Office of
Environment
& Heritage

Your reference : SSD 5248
Our reference : DOC14/53734
Contact : Rachel Lonie 9995 6837

I refer to your correspondence to the Office of Environment and Heritage (OEH) regarding the public exhibition of a Development Application and Environmental Impact Statement for the Gazcorp Industrial Estate at Lot 5 DP 24090, 813 – 819 Wallgrove Rd Horsley Park.

ATTACHMENT 1. Office of Environment and Heritage (OEH) comments on public exhibition of Development Application and Environmental Impact Statement for the Gazcorp Industrial Estate at Lot 5 DP 24090, 813 – 819 Wallgrove Rd Horsley Park.

Figure 8.1 Area proposed for excavation.

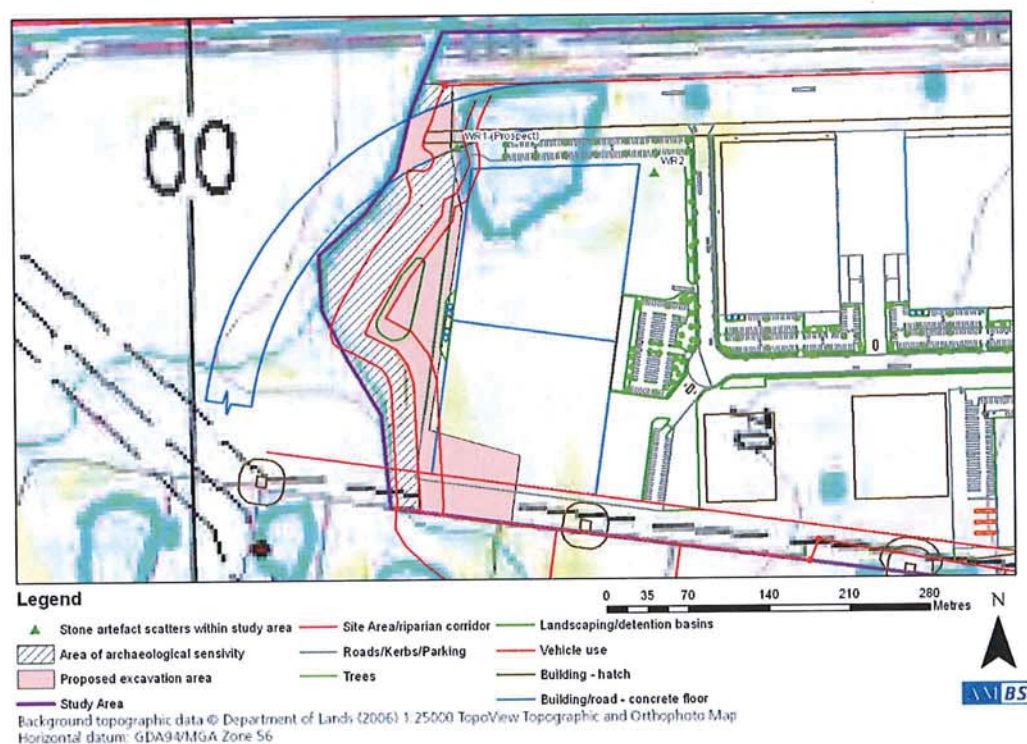
OEH does however note that the methodology outlined in Recommendation 3 of the ACHAR should to be reconsidered to ensure that it is clear that where the test pit results indicate that further archaeological investigation is warranted, expansion of those test pits should occur within the areas of impact under a salvage methodology. Should an Archaeological Site be confirmed through test excavation of the area of archaeological sensitivity, an AHIMS site card should be prepared and registered with OEH for the remaining and undisturbed portion of the site.
